# CITY OF PORTLAND BUILDING PERMIT

**PERMIT ID:** 2012-65702

86 Commercial St - 6 Custom House Wharf

has permission to **Interior renovations for new restaurant 1st & 2nd floors (change of use for 2nd floor), including structural upgrades to beams, columns & wharf bents and 2nd floor exterior deck w/outside dining on both decks (internal demo permit #2012-10-5242)**

6 CUSTOM HOUSE WHARF
 PORTLAND, MAINE
 ROOF REINFORCEMENT FOR MECH ROOFTOP UNITS
 ROOF FRAMING PLAN

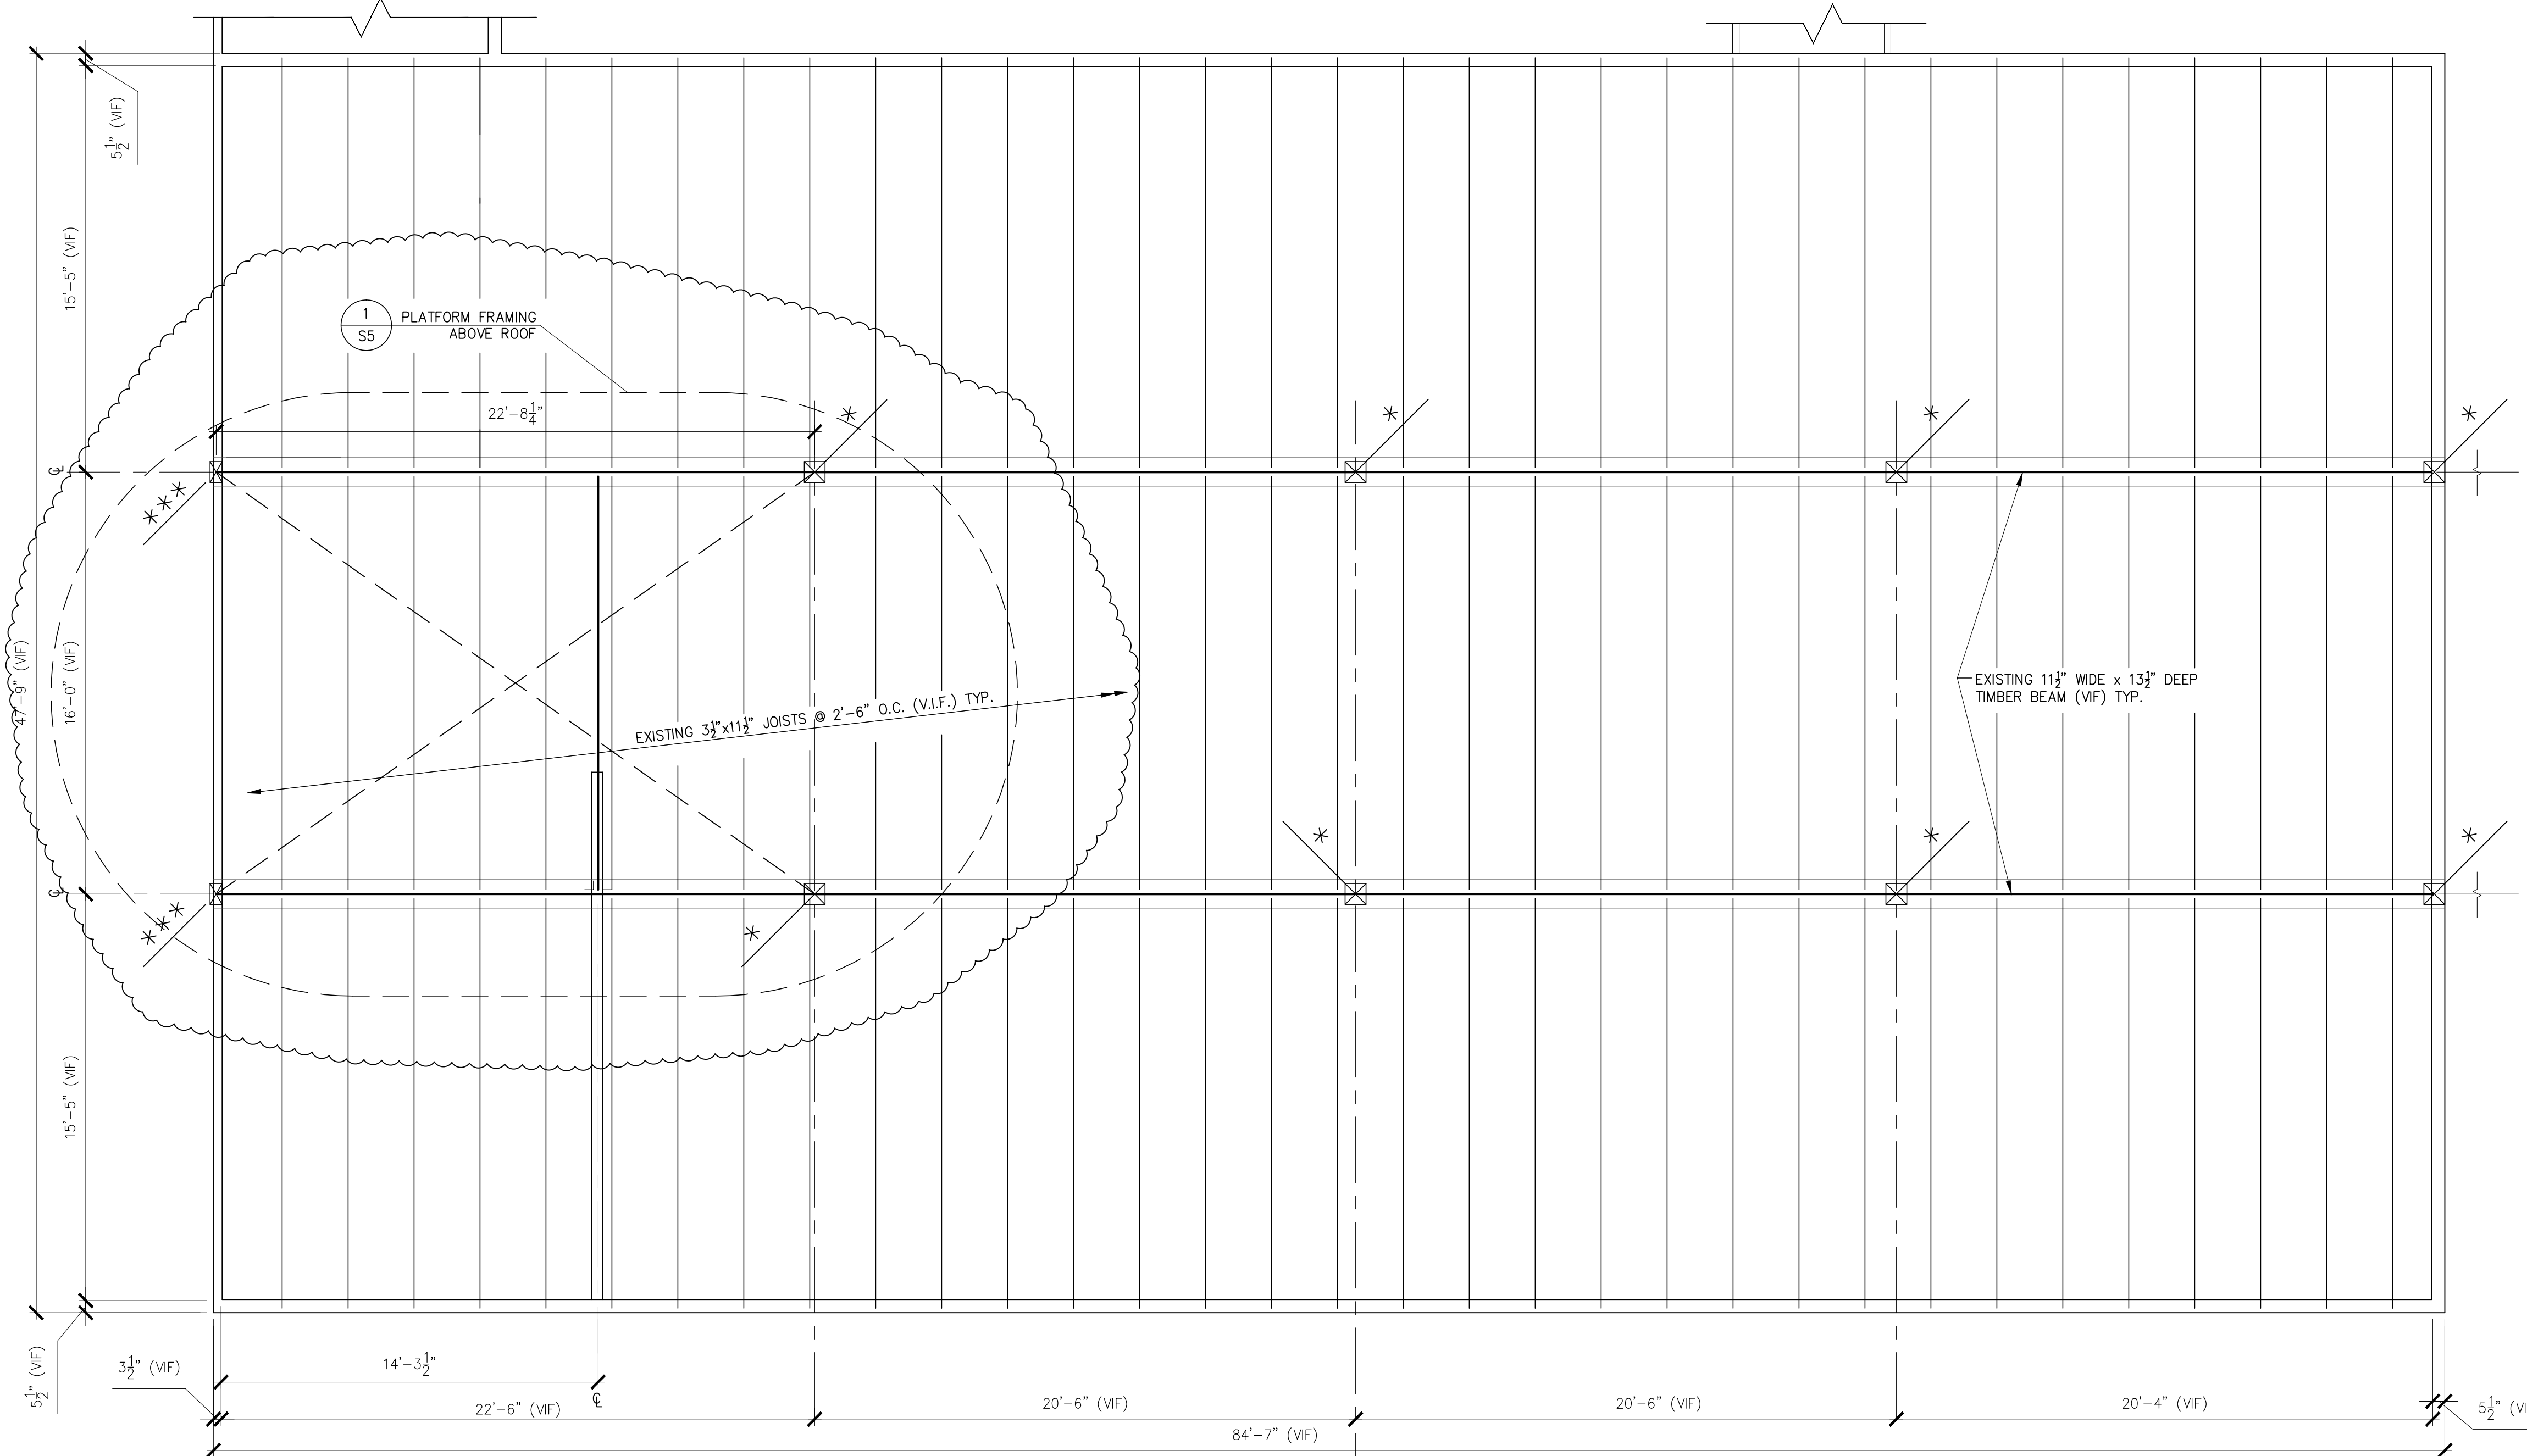
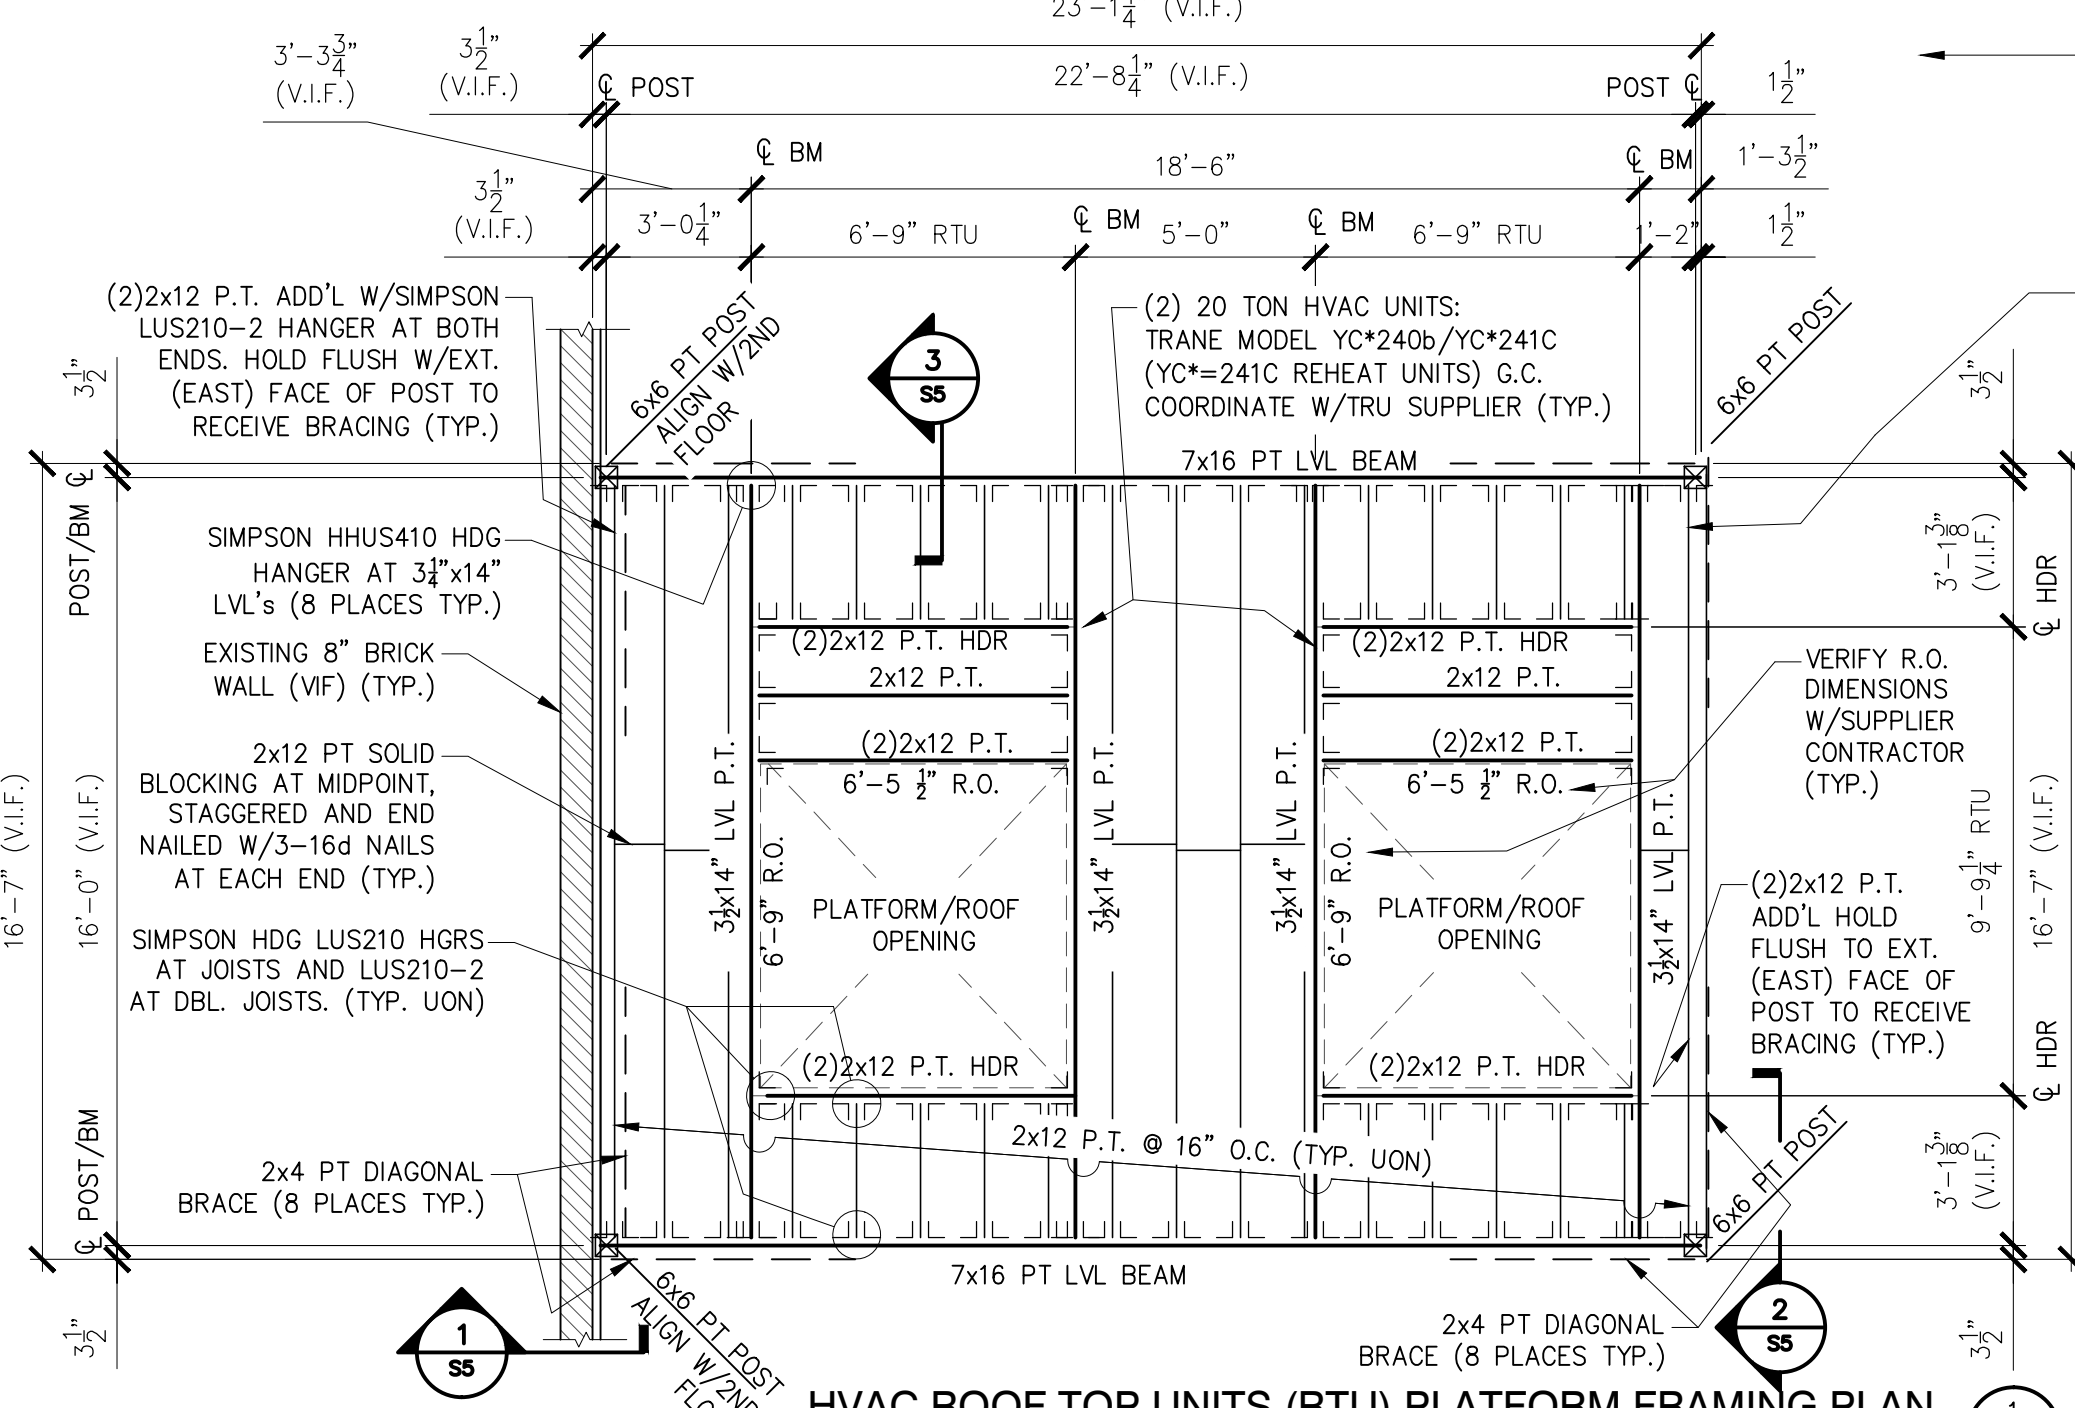
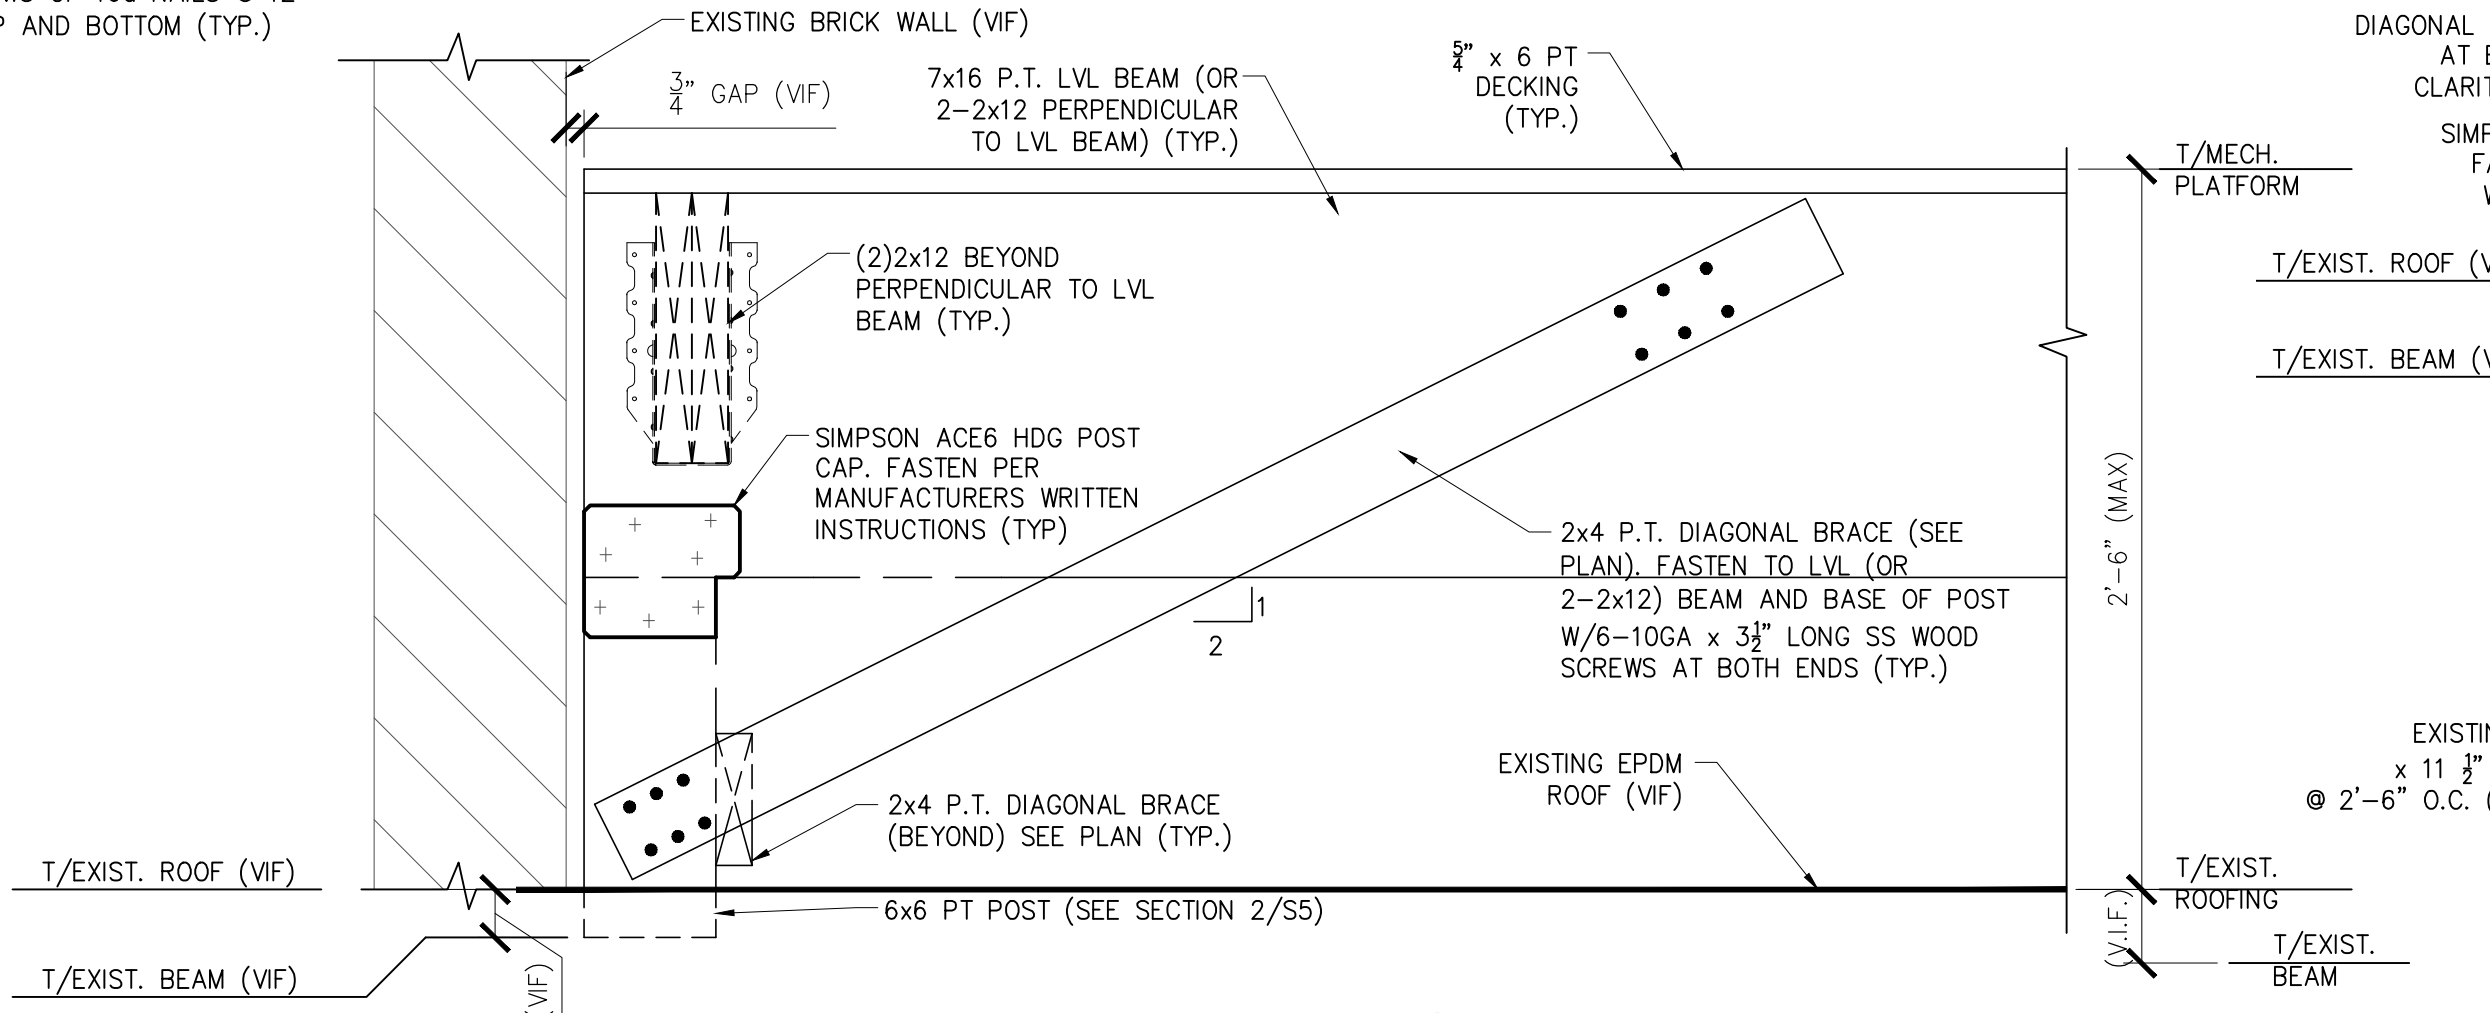
- 11) Framing/structural details for the rooftop platform for the HVAC equipment shall be submitted for review prior to commencement of this work.
